Our Case Number: ABP-316178-23

Date: 09 October 2024

Re: Proposed development of Oweninny Windfarm Phase 3 consisting of 18 no. wind turbines.
Within the townlands of Laghtanvack, Croaghaun (also known as Croaghaun West), Moneynieran, Corvoderry, Shanvolahan, Dooleg More, Shranakilly, Bellacorrick and Shanvodinnaun, Co. Mayo.

Overview Sheet

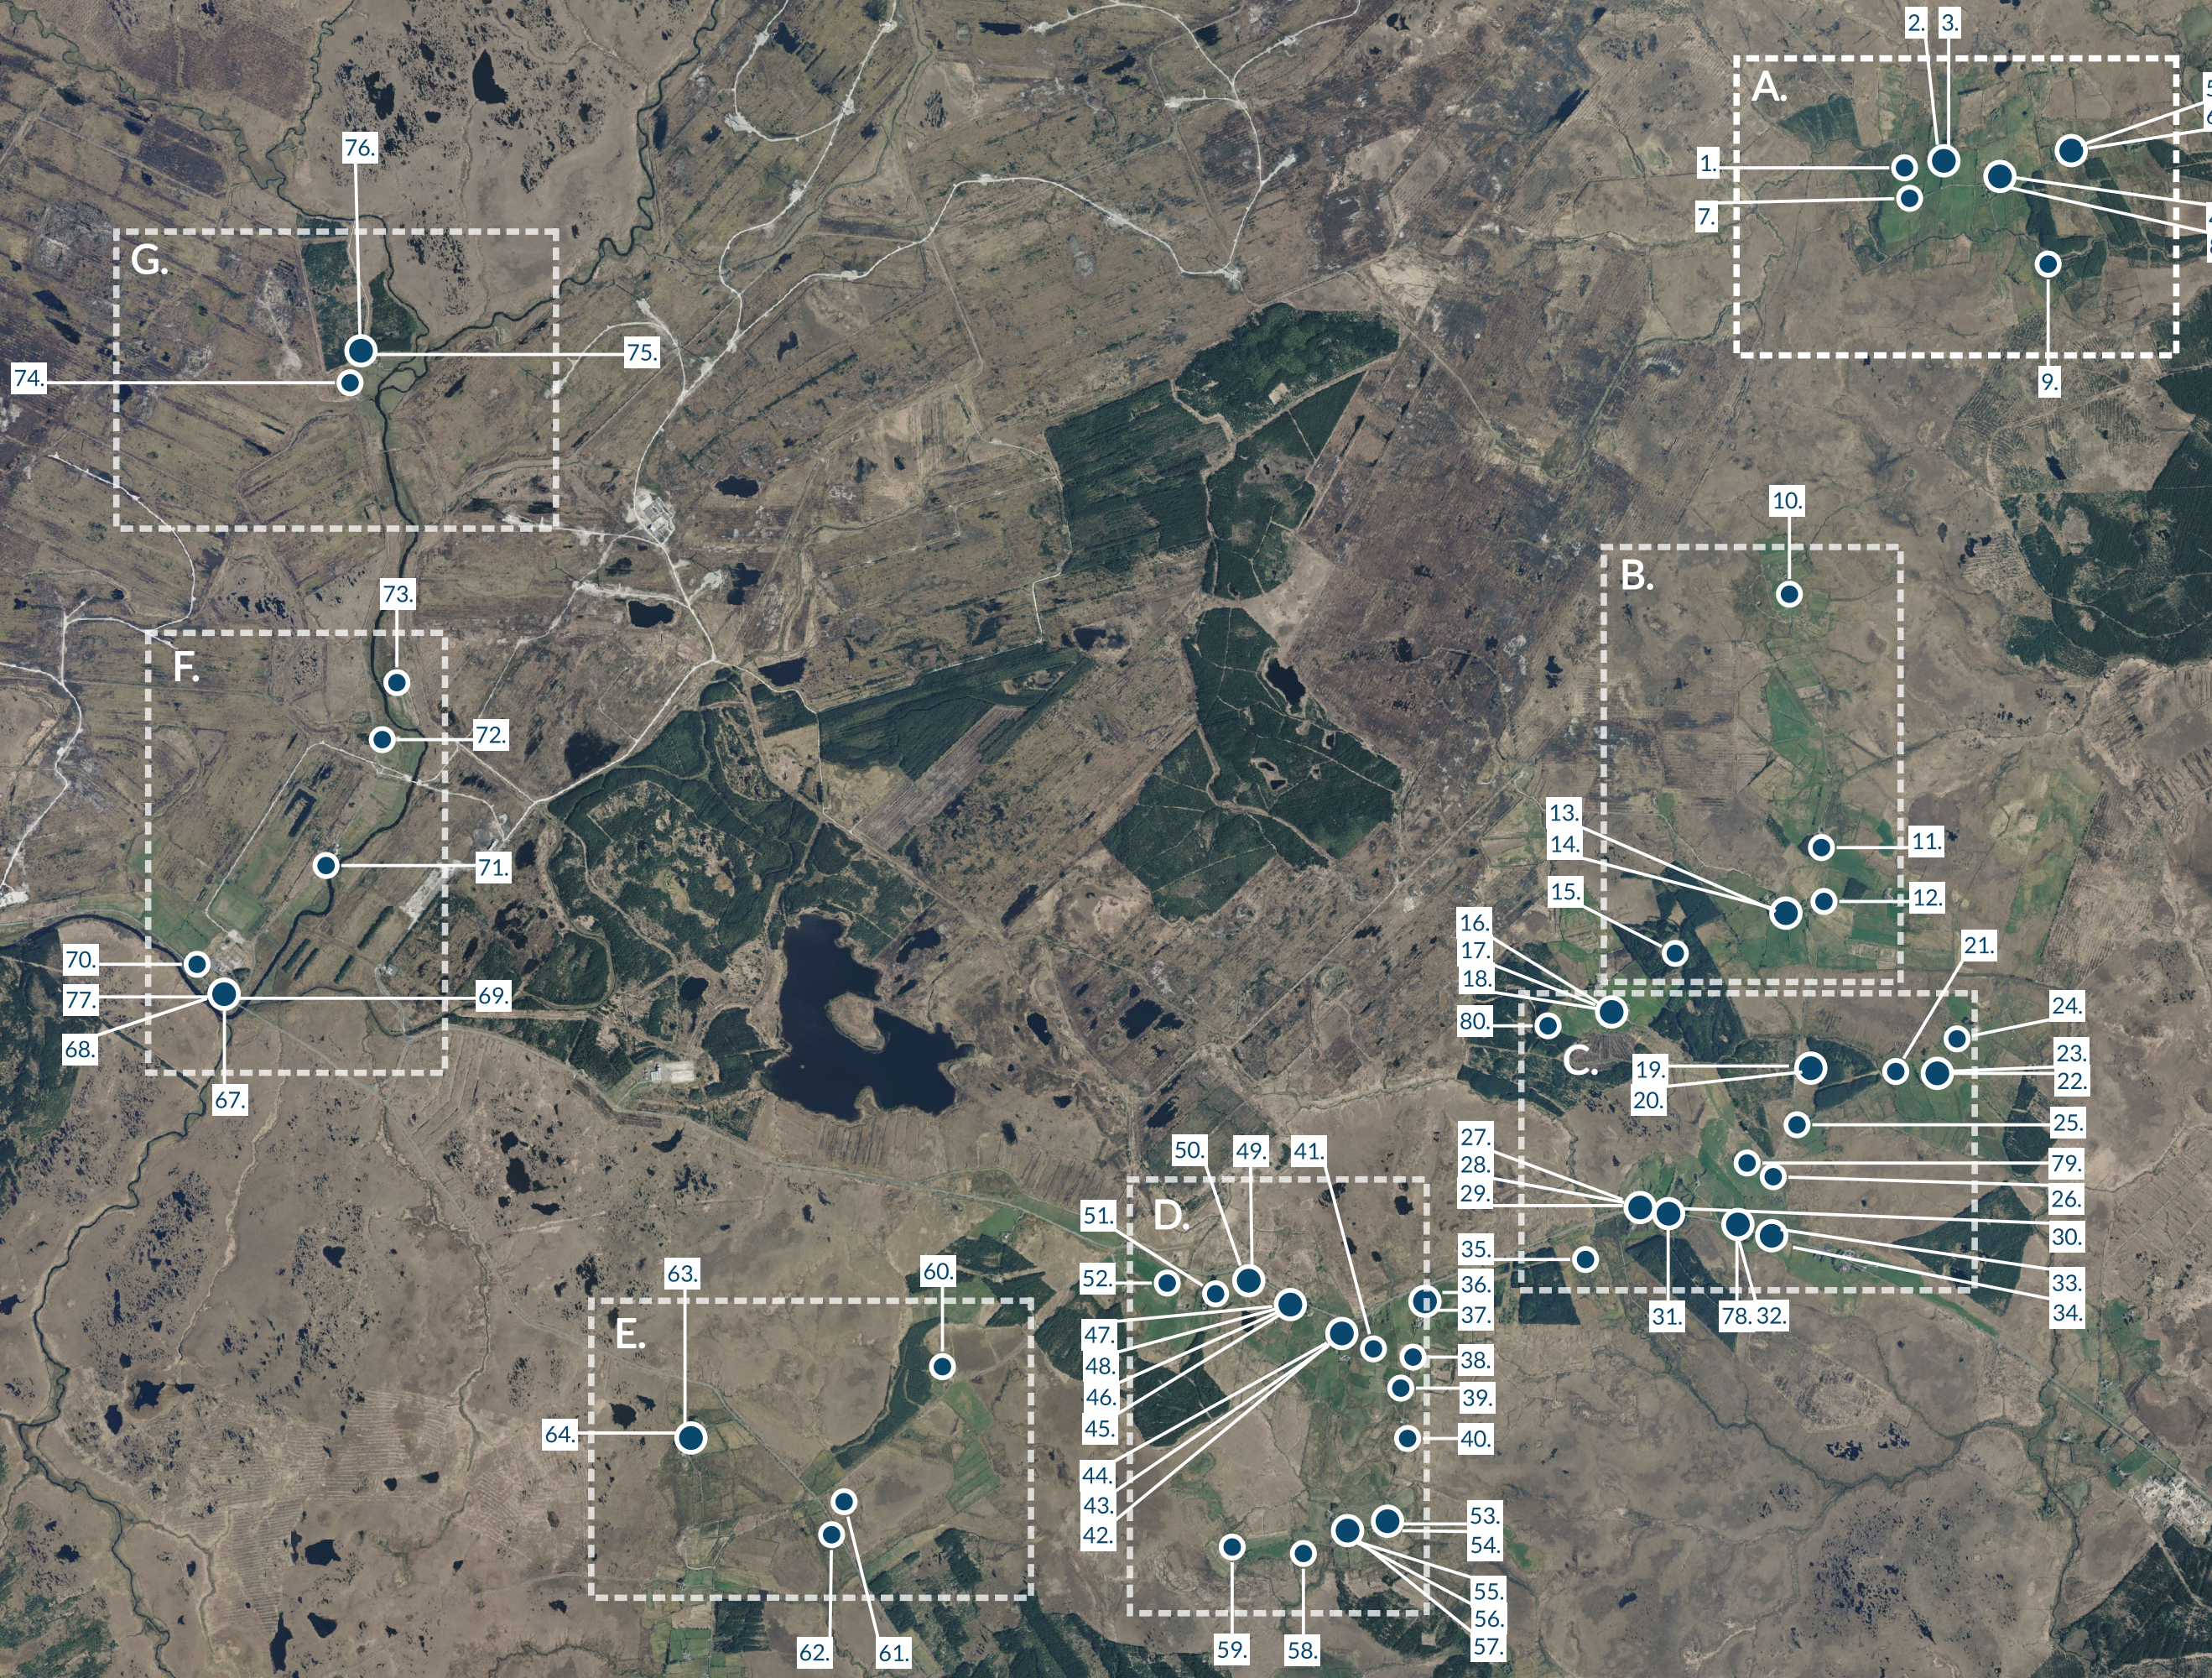
- The shadow flicker is assessed in Chapter 14 of the EIAR. Receptors are stated to be detailed in Figure 10.1, however there are no Figures in this chapter (Figure 10.1 relates to a site location map in the hydrogeology chapter).

- In Chapter 14 it states that a total of 78 number sensitive receptors were identified and are presented in Table 14.1. Each receptor identified has been assigned an ID number for reference i.e. 1 to 78. It further states that the co-ordinates (ITM) of each of the receptors have been compiled and their locations added to the WindPRO model and that the co-ordinates of each of the receptors are listed in Chapter 6 (Population and Human Health) and are not replicated in Chapter 14.

- In Chapter 6, Figure 6.2 includes a map of sensitive receptors. These are not labelled but are a series of dots. Table 6.3 presents a summary of identified receptors i.e. total number Of SR of commercial, residential, both and unknown. No coordinates are provided, nor are they labelled in any map in the planning documentation.

1.The ITM and Eircode of each of the 78 number shadow flicker receptors with an annotated map indicating each of the receptors.
